The Recreational Fishing Alliance of NSW

Kamay Ferry Wharf Project

Application No SSI-10049

Submission of the Recreational Fishing Alliance of New South Wales to the Kamay Ferry Wharves

Figure 4: Indicative schematic of the proposed wharf at the La Perouse site
(note: design development still in progress)

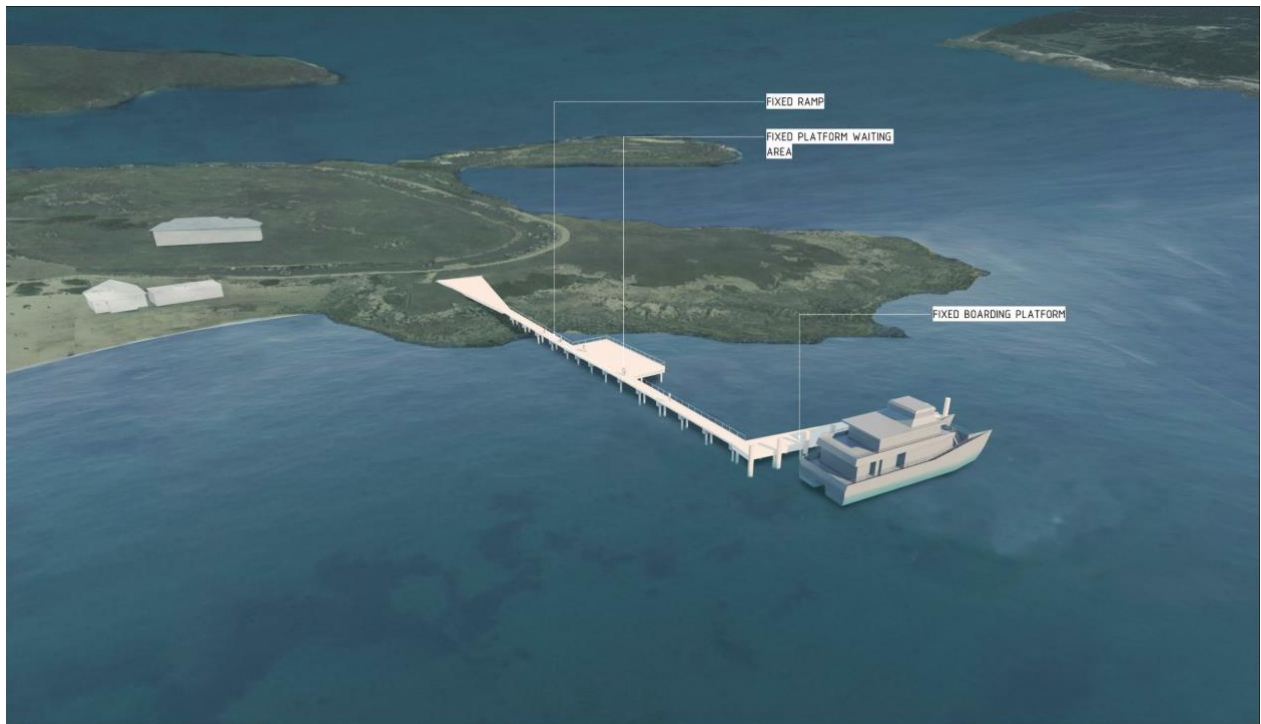
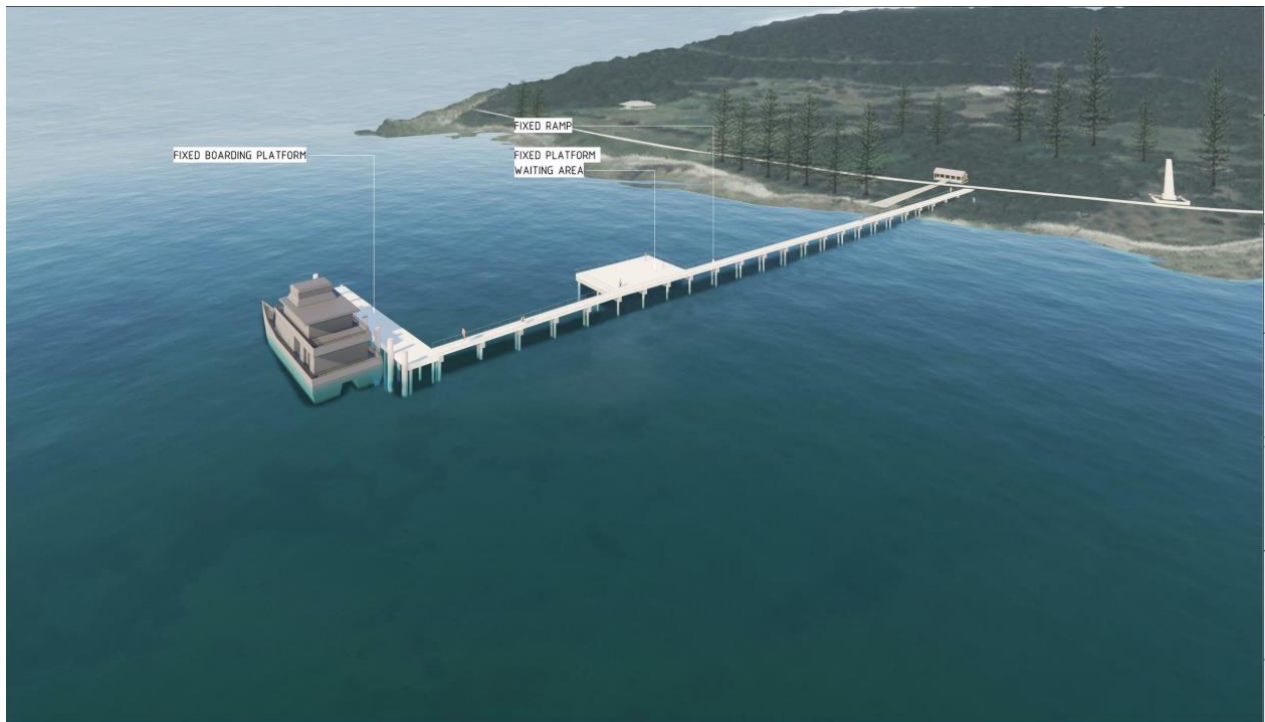
Access to fish recreationally off wharves or provision to upgrade them with dedicated fishing platforms was discussed previously and the design will result in wharf users and fishers being in close proximity of each other. As we would be losing access to a safe, sheltered family friendly fishing areas at Laperous due to the new wharf footprint it was hoped to see larger areas to fish from towards the end of the wharf. Previous discussions also focussed on having the wharves accessible to fishers, making them fishing friendly with multiple freshwater taps, they be disabled angler friendly with lower handrail sections, interactive bag and size limit info, dedicated bins along the wharf and even dedicated fishing areas with extra offshoot platforms and this seems to have been ignored.

Annex 2 – Typical Recreational Vessel and Ferry Tracks

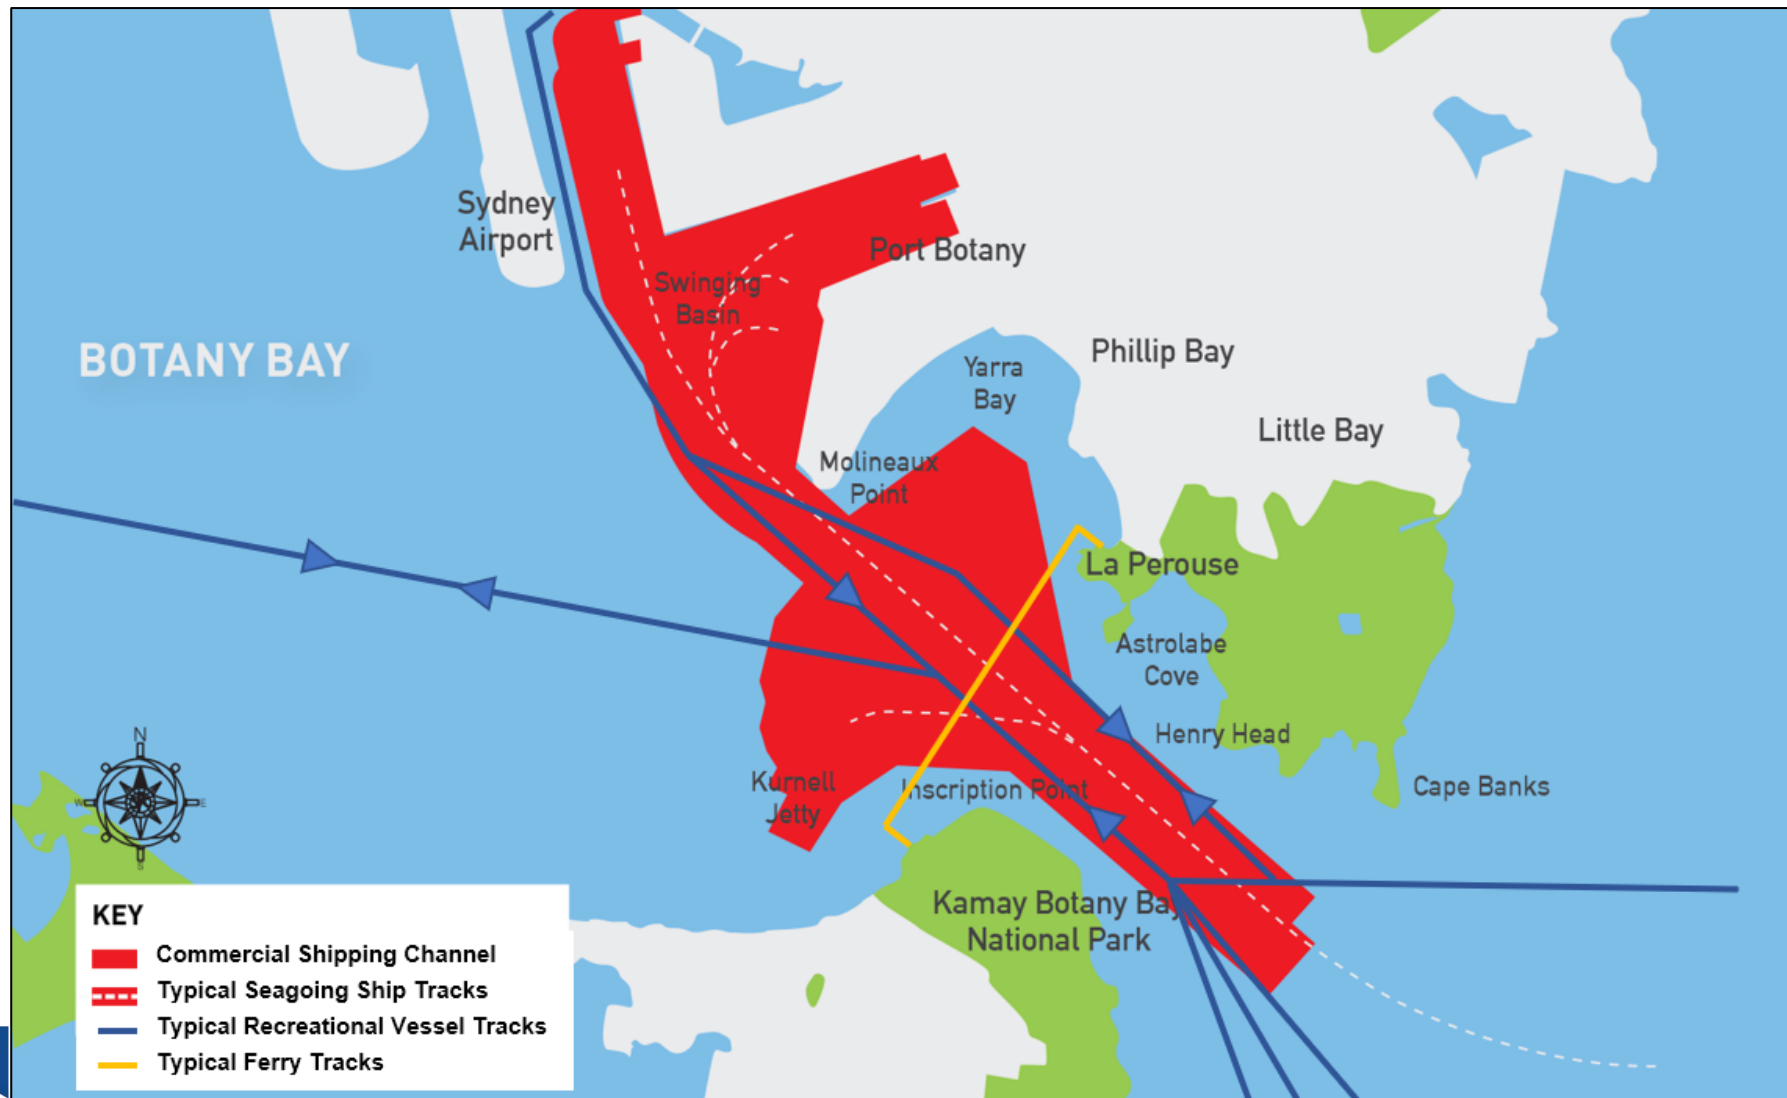
In June 2020 the RFA told the consultants to avoid our fishing areas with regards to any ferry route and at the time there seemed to be consensus. Imagine the RFA's surprise when the EIS was released and the "Ferry Swept Path" went straight over our recognised fishing grounds and the areas we told them to avoid. Whilst we understand that this is the proposed ferry swept path, we are asking that this be reviewed and that the EIS reflect a new ferry swept path and the impacts, if any a new ferry swept path will have.

The EIS has missed the fact that the ferry sweep area will impact safe boat fishing spots in a southerly wind / swell. We have already provided advice on the areas that a ferry would have to use as a designated route and this was ignored. Any ferry route would have to stay well away from recognised fishing / spearfishing grounds at Kurnell and Laperous. Routes would need to circumvent these areas to reduce conflict. Whilst these might be construed as management issues, they should also help shape the EIS and areas where we should be focussing on and looking at the likely impacts of having a medium ferry constantly driving over sensitive areas daily, something that is not happening now. Recreational anglers have already advised of their preferred route to reduce conflict and that was entry and exit to both wharves from a westerly direction.

Recent advice we have received on the 9th August 2021 from consultants indicates that *“The swept ferry path shown in Figure 5-13 of the EIS is the total area within which ferries could potentially move between the two wharves for the purposes of the environmental impact assessment studies. However, before the wharves are operational and a ferry operator is selected an operational management plan will be developed in consultation with recreational user groups (including the fishing community) to include a designated ferry transit route and exclusion areas to minimise impact on existing and future activities in the bay. We certainly took note in our meetings on the information you provided on recognised and safe fishing areas, and this will be considered in the development of the ferry transit route and operational management plan in general”*.

The consultants response raises issues that need to be addressed now and not with an “operational management plan” as indicated at a later date. Recreational fisher’s advice is to change the ferry swept path now under this EIS. The preferred route that recreational anglers want considered needs to be assessed under the same processes as the current ferry swept path since it is outside what the current EIS has looked at. Environmental management measures need to be reconsidered in the new ferry swept path and should focus on habitat degradation and turbidity on sensitive environments related to vessel wash and disturbance.

Figure 10-9: Construction impacts at La Perouse

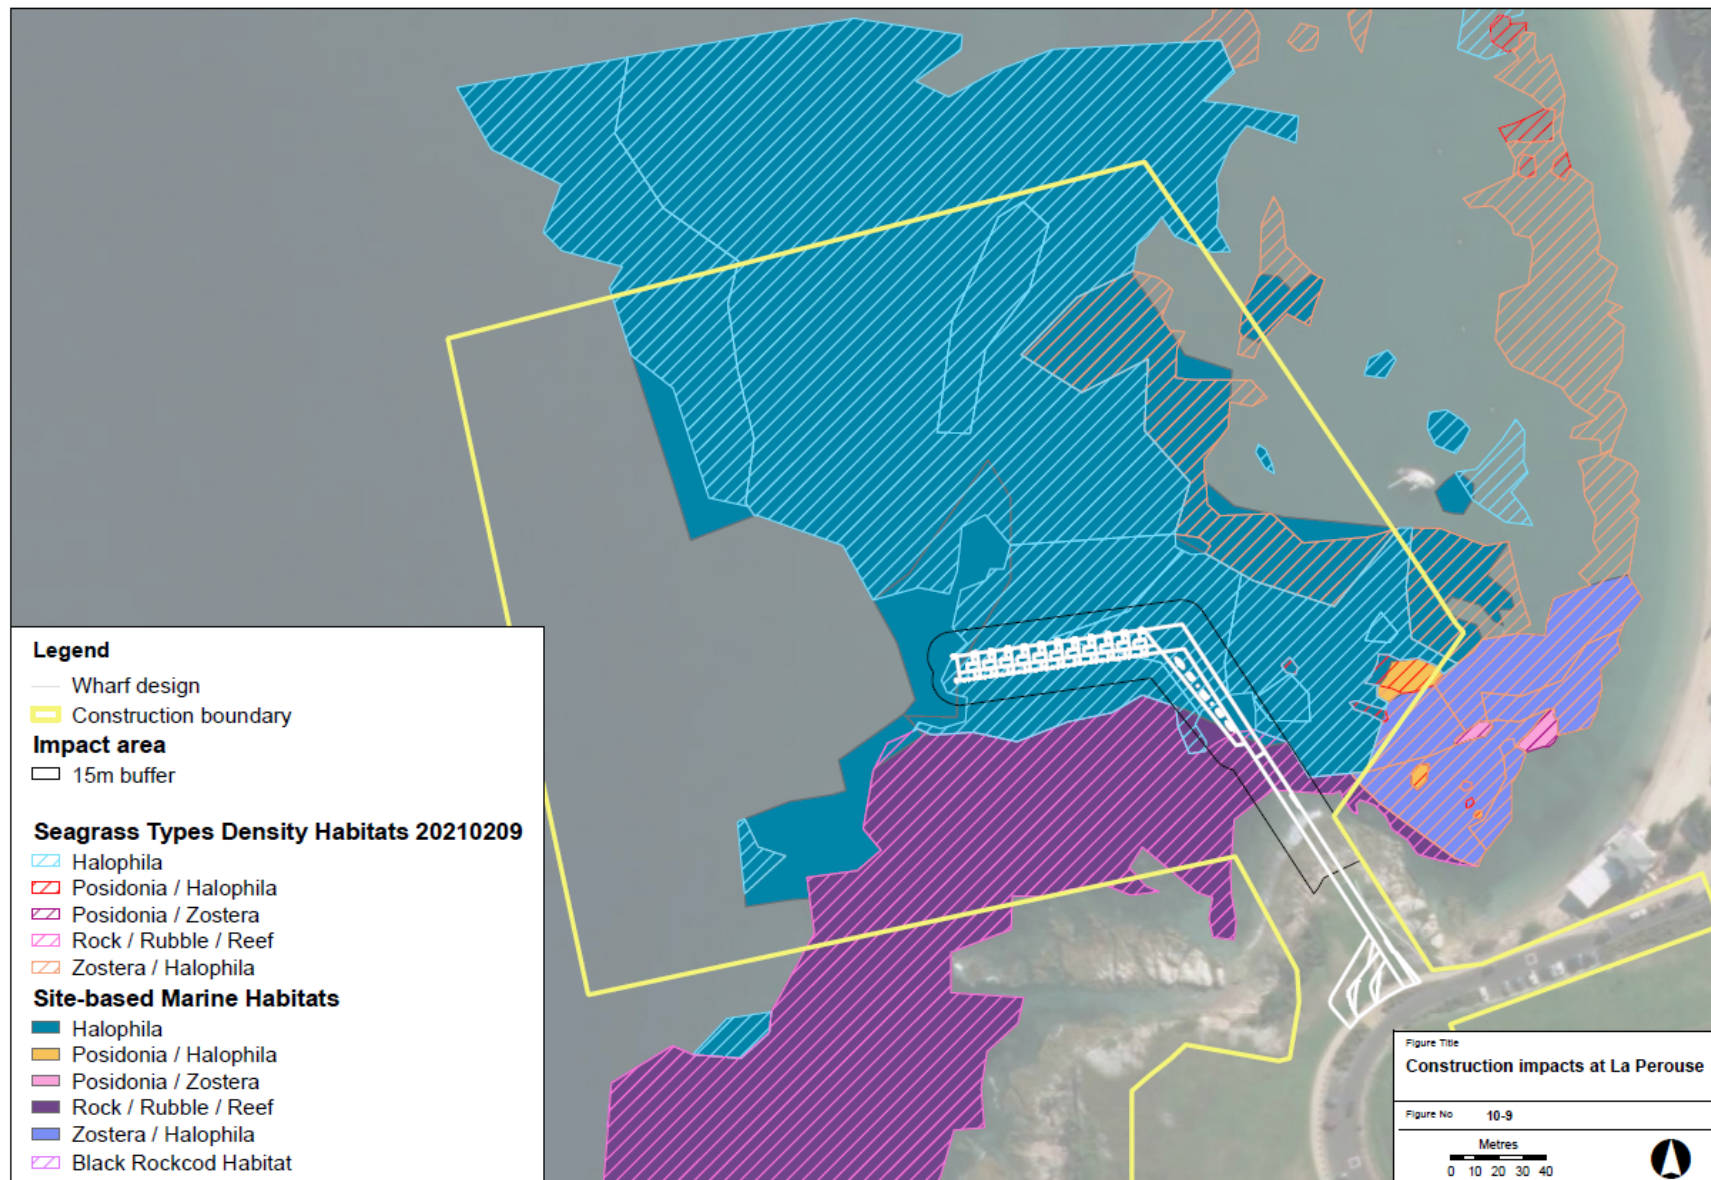
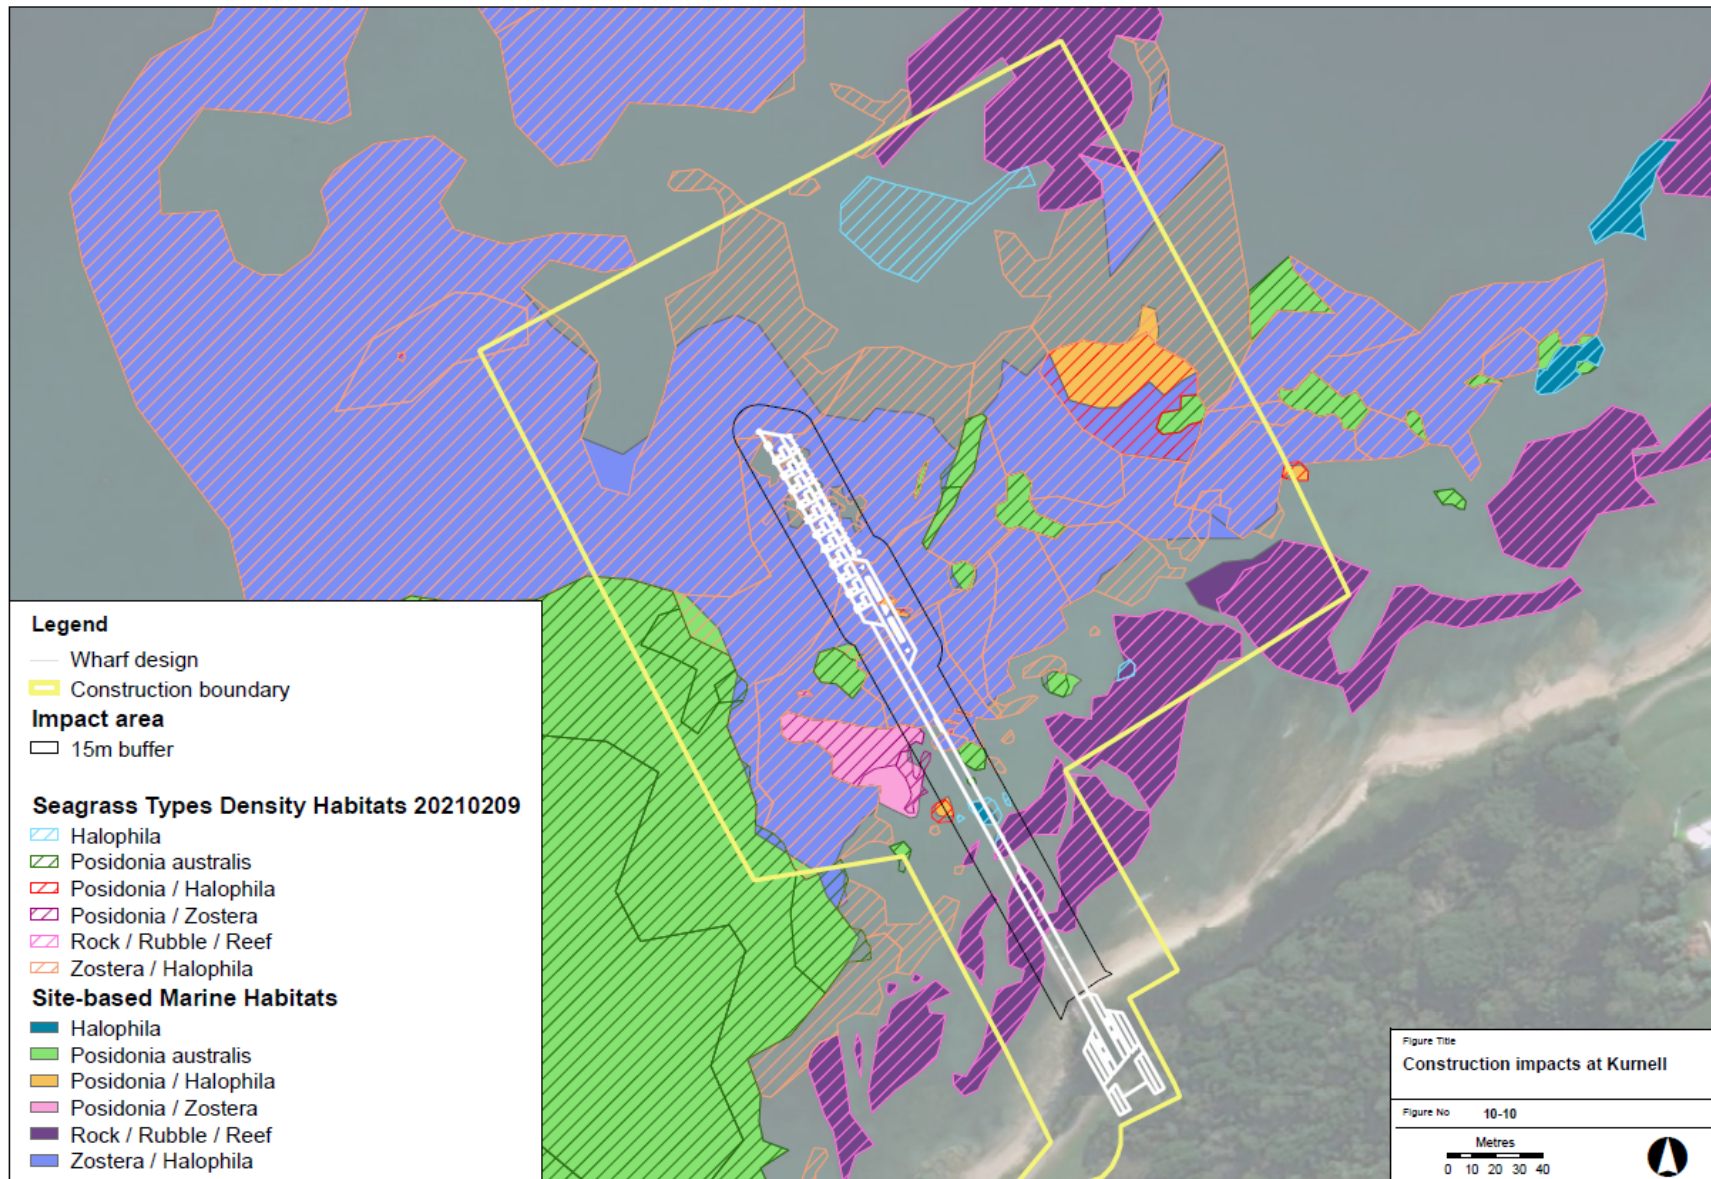
The EIS seems to constantly be talking about sea grass and threatened species and mentions “octopus” as inhabiting the area. It fails to acknowledge that these areas are also nursery areas and the shellfish in the area that will be impacted by the construction works and constant travel that these ferry’s and other vessels will be having over these areas.

Most of the previous EIS' in the Bay have focussed on sea grass, not fish assemblages and spawning aggregations of species like cephalopods and this EIS is deficient in this once again.

Any assurances that the seagrass offsets could be used are also false based on previous assurances given by the NSW Government with regards to the Port Expansion at Port Botany and the associated failed attempts to transplant seagrass meadows that the Port Expansion destroyed. This EIS, like previous studies pays little regards to the role of seagrass and the impacts of any loss due to developments like this one proposed. **We are advised that there will be ongoing impacts from the ferries to the habitat in the area and that offsets can be used. It is misleading to suggest that this is a viable solution and the EIS is misleading in this regard.**
